7 May 2021

SSI-10040 – SUBMISSIONS REPORT - PROJECT ENERGY CONNECT (NSW – WESTERN SECTION)

Figure 2.1 - Location of Silver City Highway access point (Access Point 84)

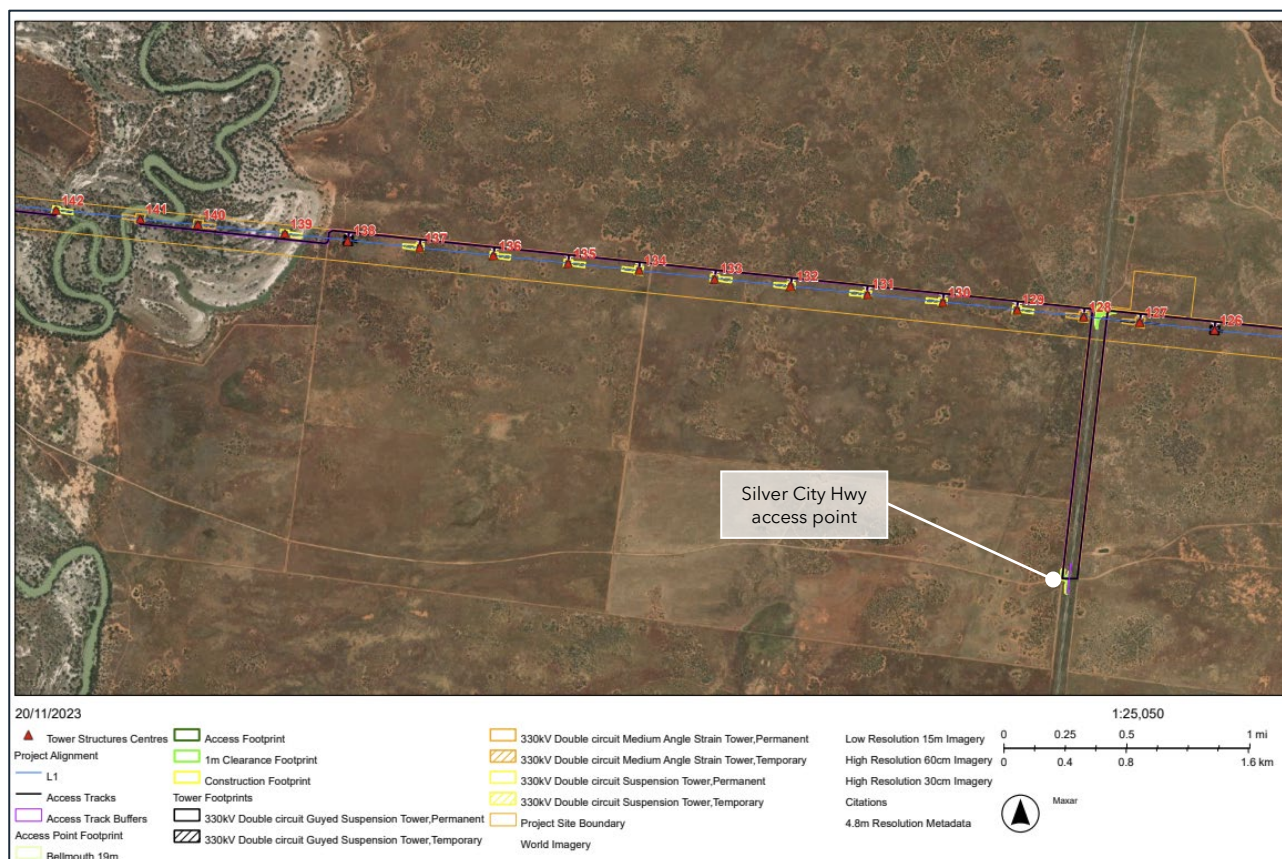
Note that as the Silver City Highway and the Sturt Highway are part of the State Road network the developer may be required to enter into a Works Authorisation Deed (WAD) with Transport for NSW before finalising the design or undertaking any construction work for access driveways within or connecting to the road reserve. The applicant is to contact the Team Leader Land Use for the South West Precinct on Ph. 02 6923 6611 for further detail. Works within the road reserve of any classified road shall be located, designed and constructed in accordance with the requirements of Transport for NSW and the Austroads Guide to Road Design for the posted speed limit and to cater for the largest size vehicle likely to access the site.

Section 6.11.2 of the Amendment Report acknowledges that given the location of these compounds within a high speed environment that the intersections for access to the compounds would need to address relevant safety requirements and need to provide for a Basic Right Turn (BAR) and Basic Left Turn (BAL) intersection treatment as a minimum notwithstanding the traffic volumes. As the classified road listed above are road train routes these treatments are to be design and constructed in accordance with the Austroads Guide to Road Design for the posted speed limit and adopt a B-Triple heavy vehicle as the design vehicle.
